**Subject: Comments for Development Hearing Officer on
September 25, 2024
Albuquerque, Bernalillo County, District Three**

Project Number: PR-2019-003030

Case Description: Vacation of a 16' wide alley along the west side of the property between McKnight Ave. NW and I-40 frontage Rd.

VACATION EXHIBIT PROPOSED TRACT A & TRACT B CORONADO PARK

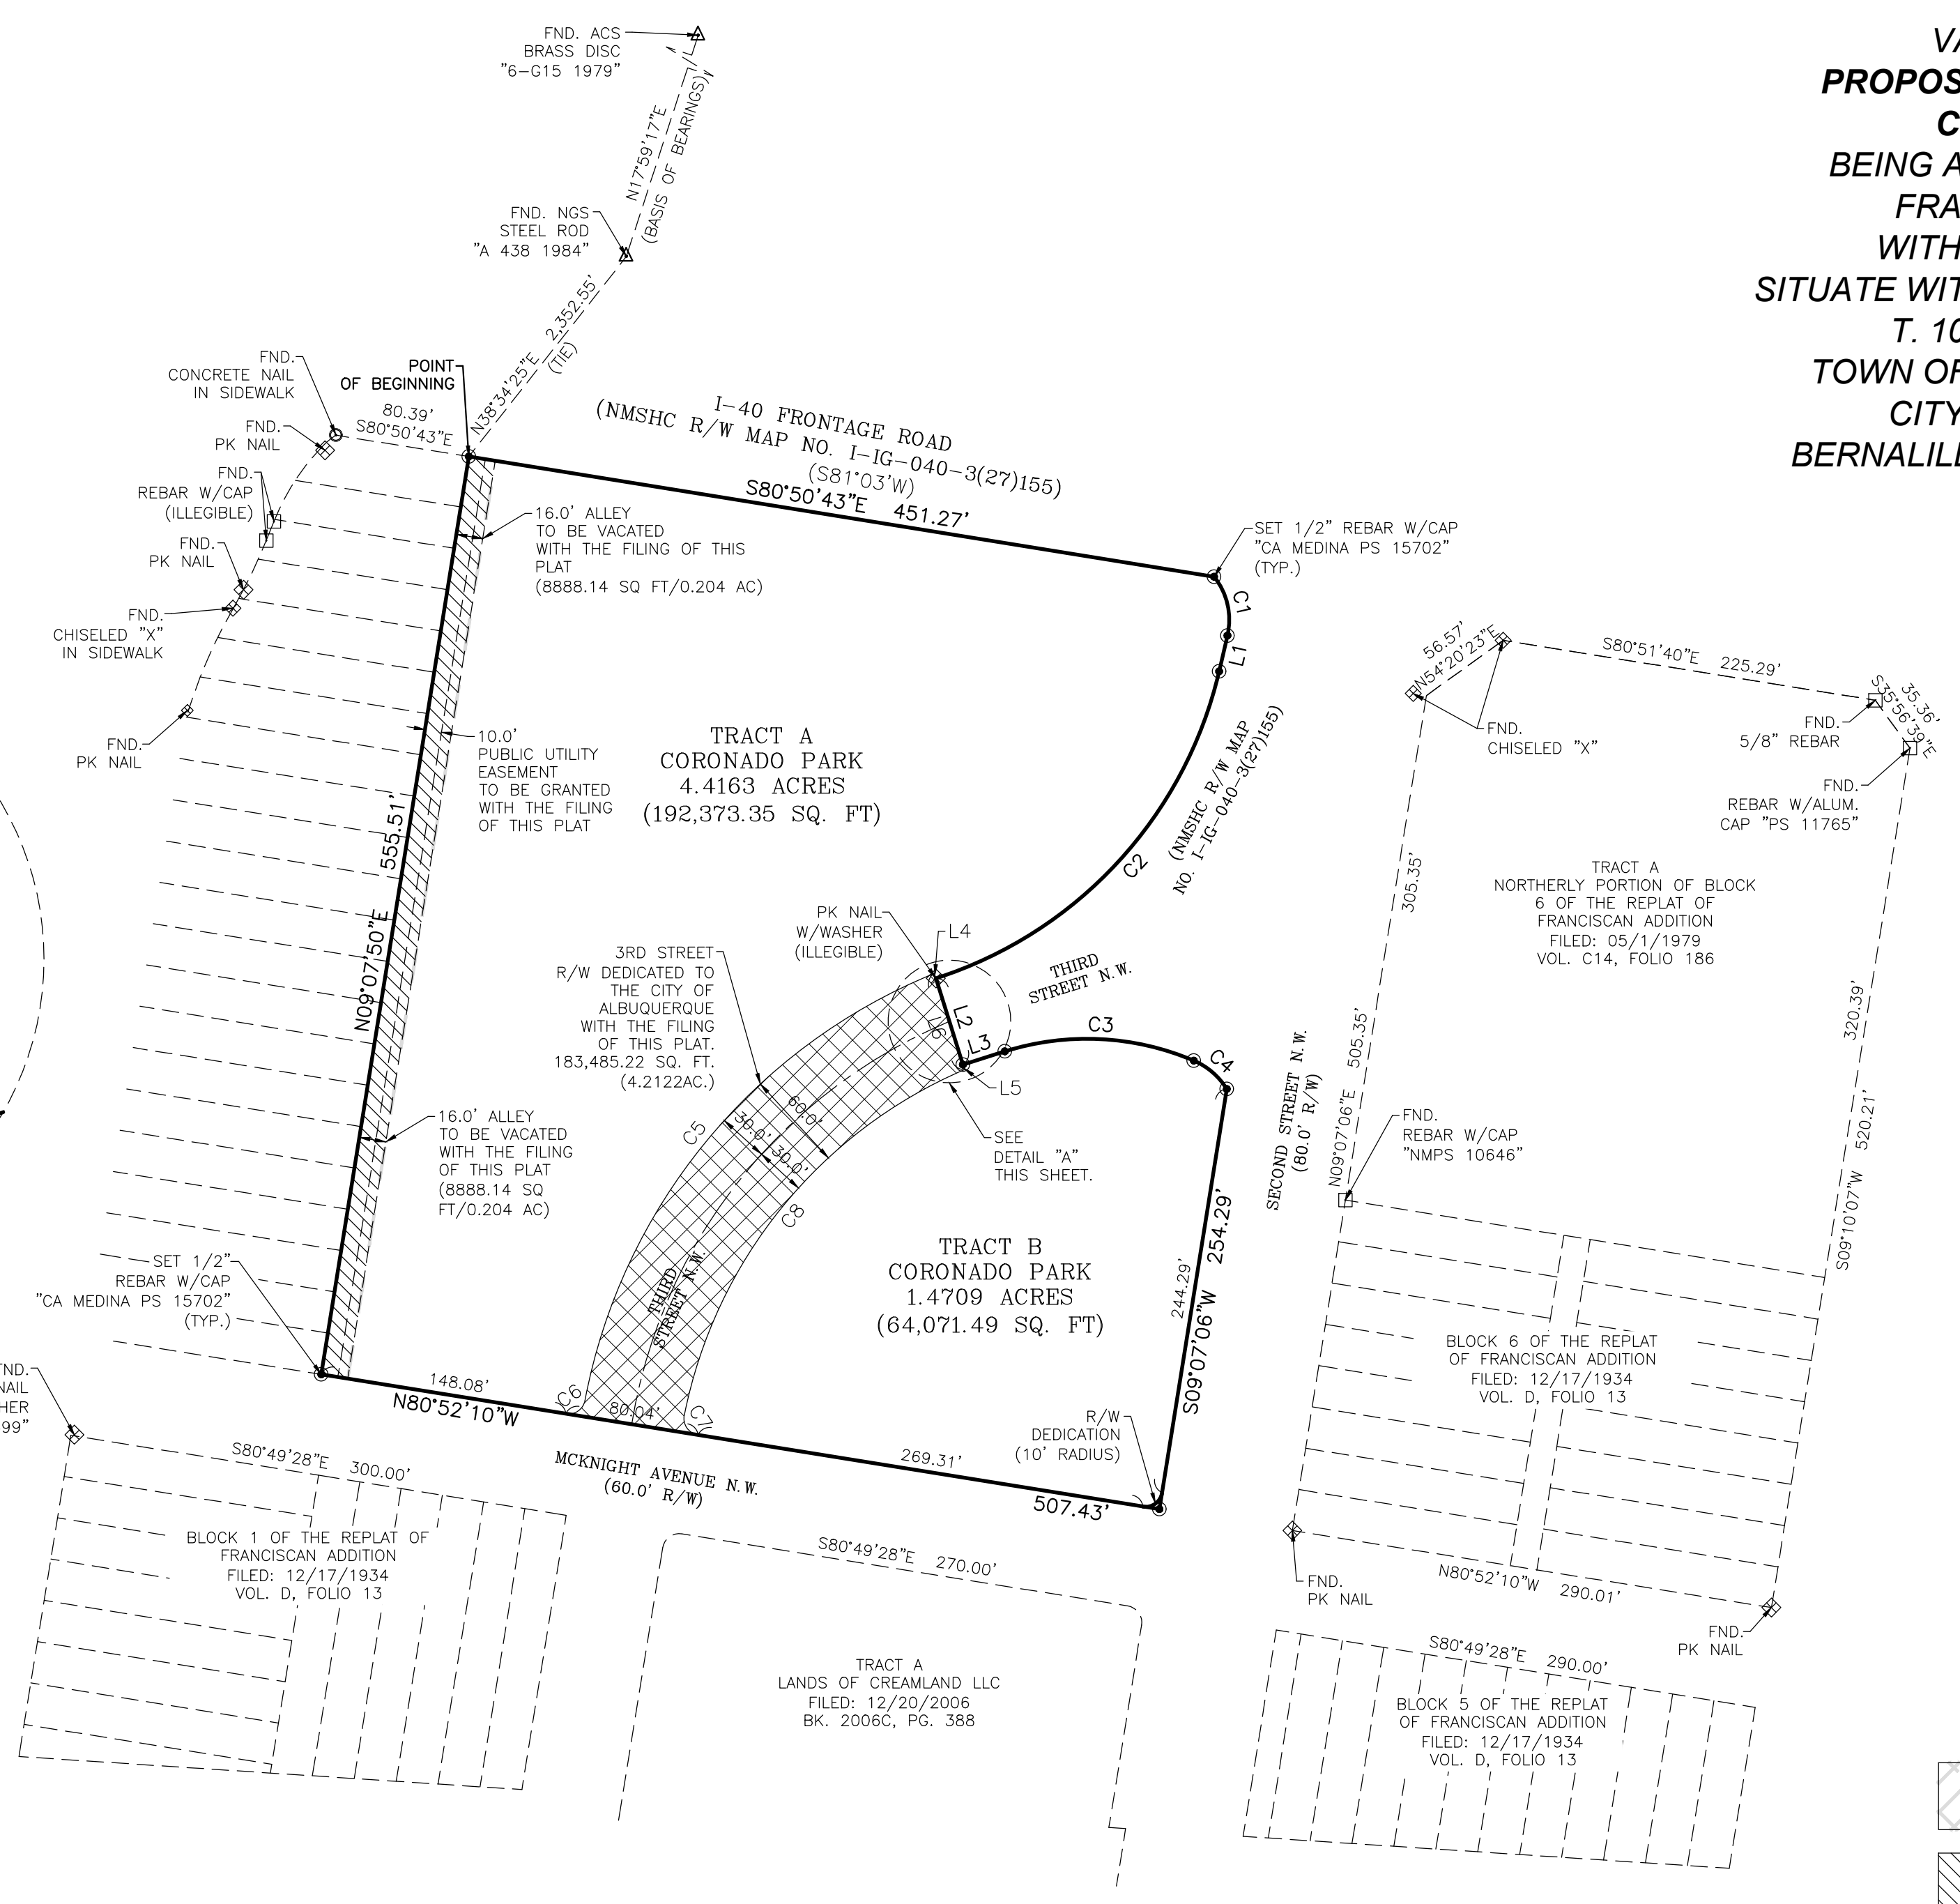
1. Please add MRGCD signature line with other signatories.
2. Please add MRGCD approval note also.
3. Final Plat Approval signature required by the MRGCD.
